RE: Resubmittal of Site Plan-DFT_PR2019-002765_SP-2025-00003 | Comment Response Letter

The following memo provides responses to DFT staff comments for Target ABQ W Site Plan located at St. Joseph's Dr NW between Coors Blvd NW and Atrisco Dr NW on February 12th, 2024. Staff comments are in *italic* followed by the Applicant responses that are in **red and bold**.

SHEET 2C OF 5

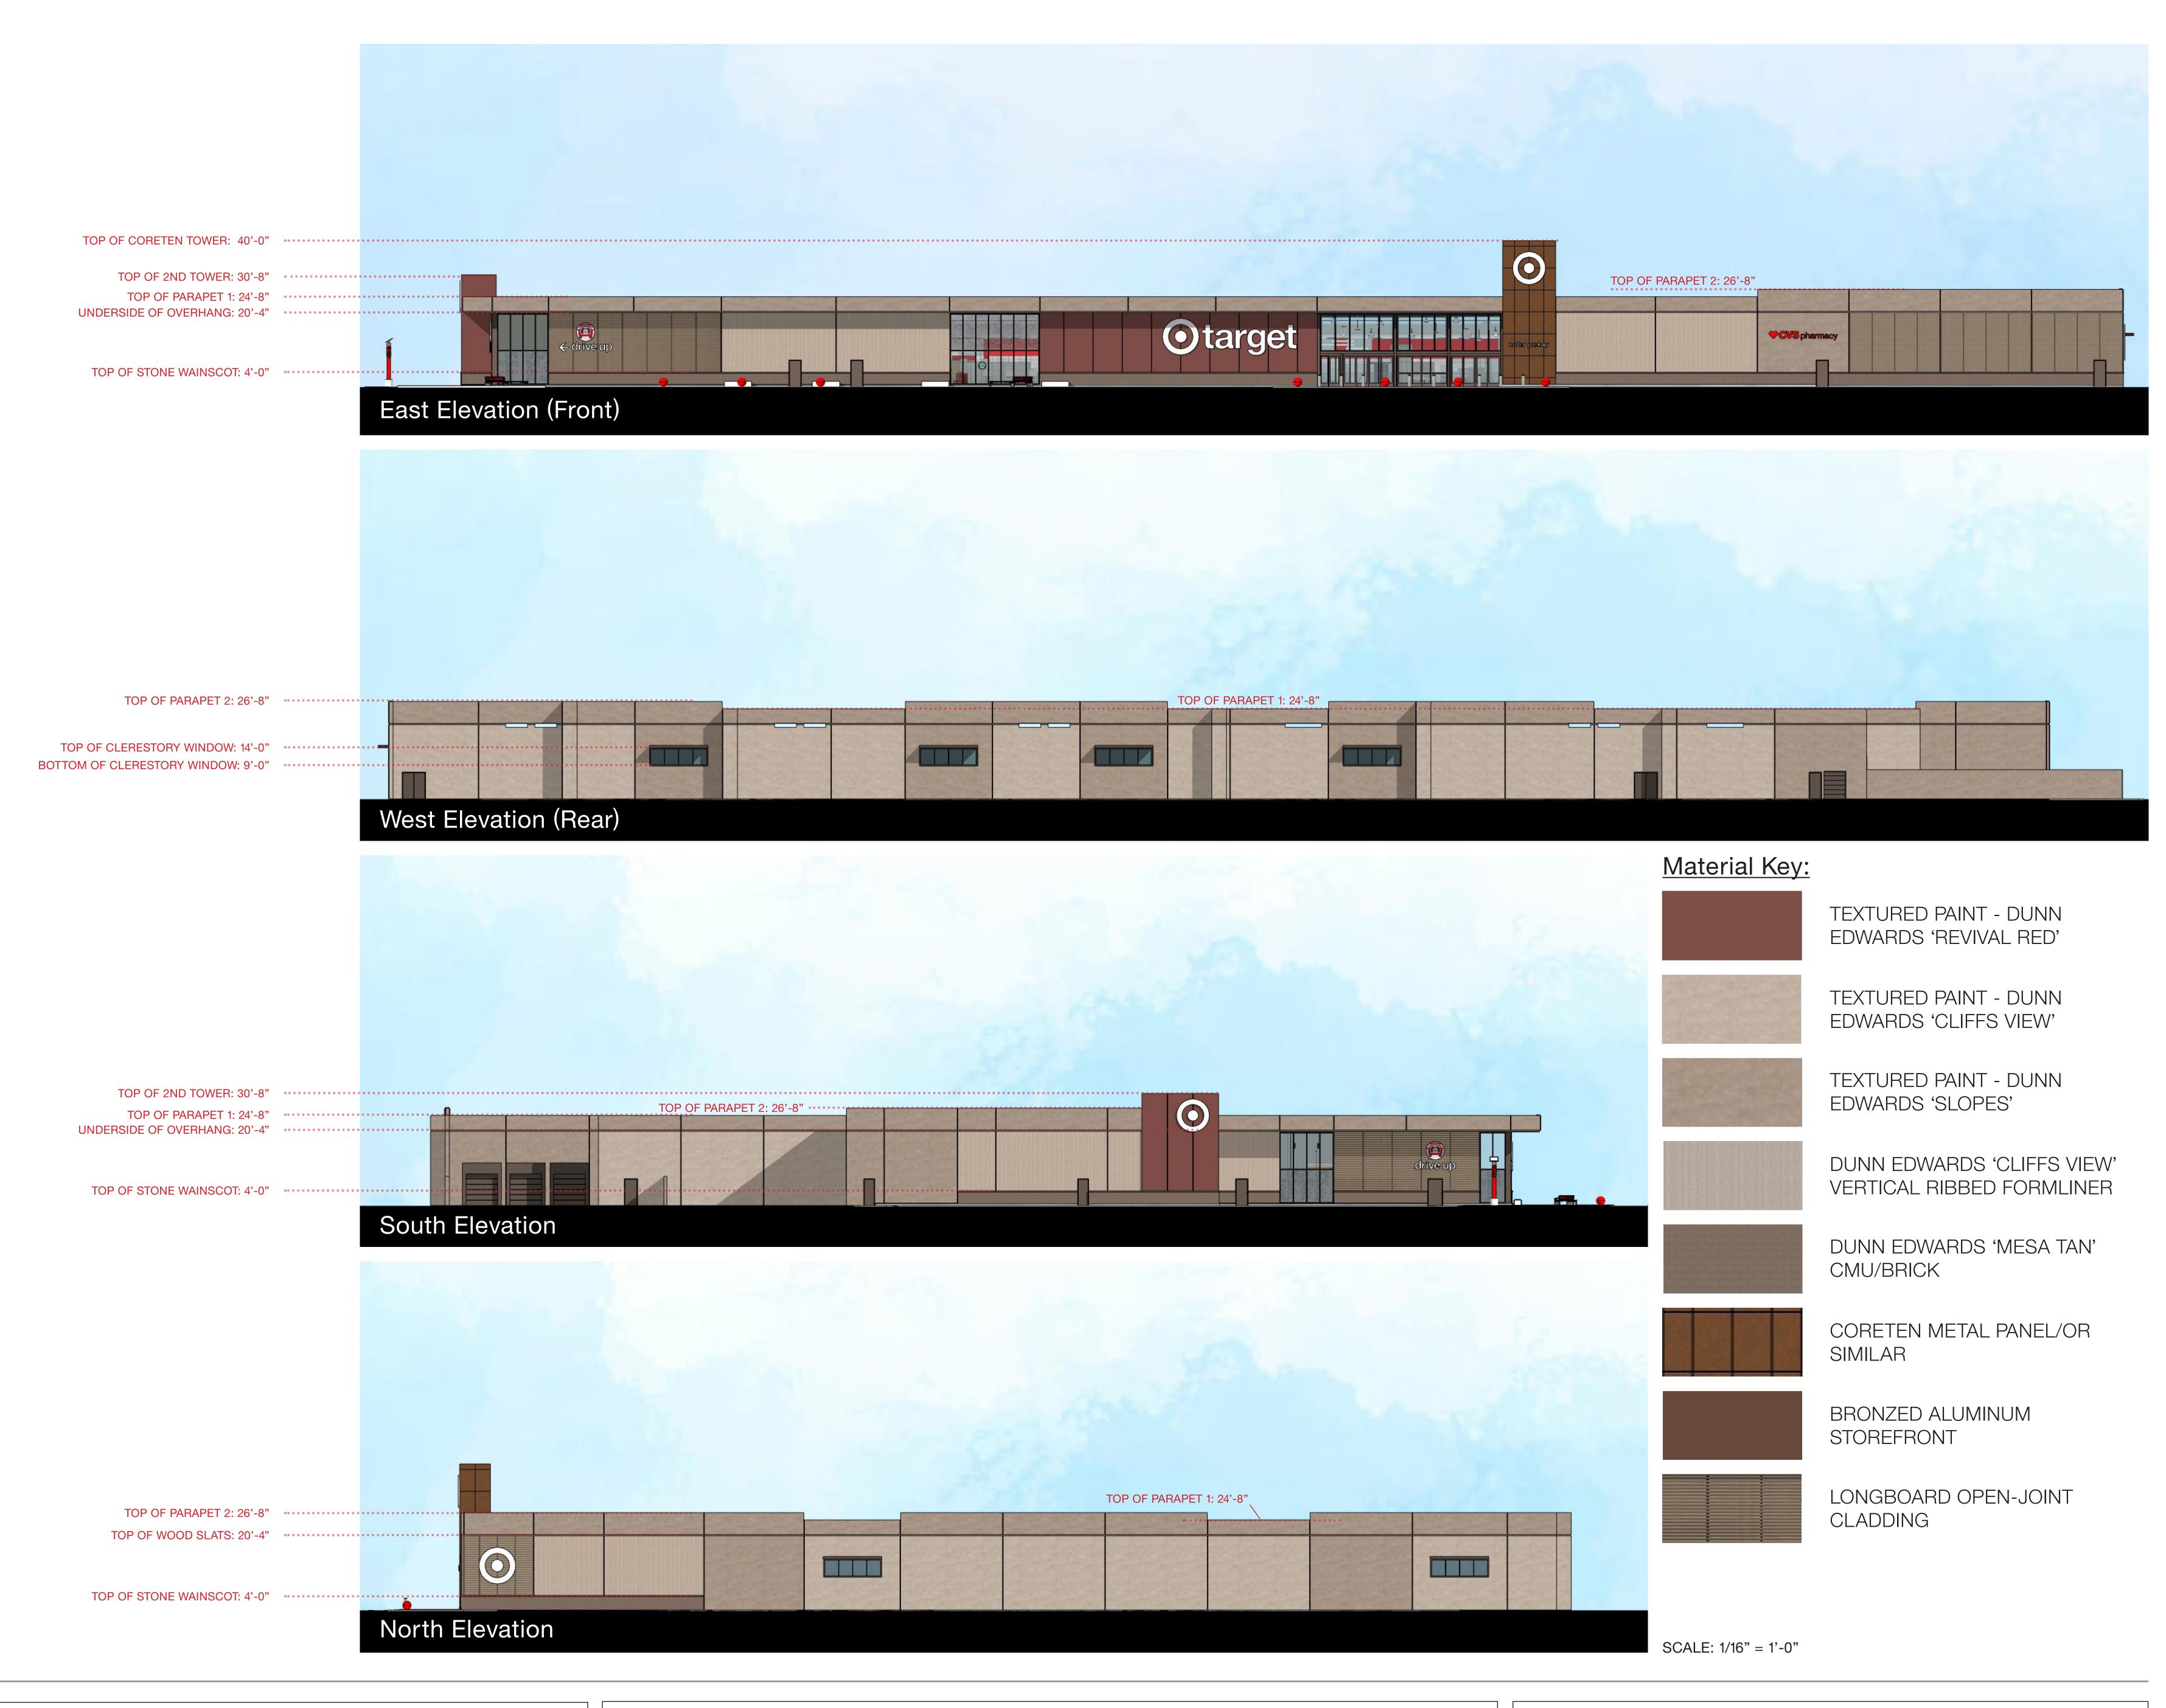
2. *Tree palette needs to be reviewed by City Forestry. For street trees and all other areas on the landscape plan use more than one type of tree and alternate the trees to avoid any future spread of disease among similar tree species.*

4. *Forestry will not accept Gambel Oak as a street tree as it does not meet the intent for street trees to provide shade. Please select a large deciduous shade tree for street tree requirements. Per IDO 5-6(C)(5)(e) Organic mulch is required as a ground cover under trees within a 5-foot radius around the tree trunk, but not directly against the tree trunk. In these areas, weed barrier fabric is prohibited. Please provide updated tree planting details showing these requirements have been met. (*Emailed comment from Hannah Aulick on 2/18/25*)*

a. minimum of 15 percent of the net lot area of each development shall contain landscaping. *Total required landscape area based on the net lot area must be added to the landscape plan.*

5-6(C)(5)(c) The use of gravel or crusher fines as ground cover is limited to a maximum of 75 percent of any landscaped area. *Calculations of total gravel mulch and total none gravel mulch needs to be added to the landscape plan.*

Applicant Response: Gambel Oak has been replaced with Chinquapin Oak (*Quercus muhlenbergii*) which is listed as a recommended deciduous tree in the City of Albuquerque Official Plant and Sizing List. Additionally, the tree planting detail has been revised to show organic mulch within a 5-foot radius around the tree trunk. See plans.

Applicant Response: Net lot area calculations and required landscape have been added to the Landscape Code Standards table on sheet 2A. See plans.

Applicant Response: Gravel mulch and non-gravel mulch area calculations have been added to the Landscape Code Standards table on sheet 2A. See plans.
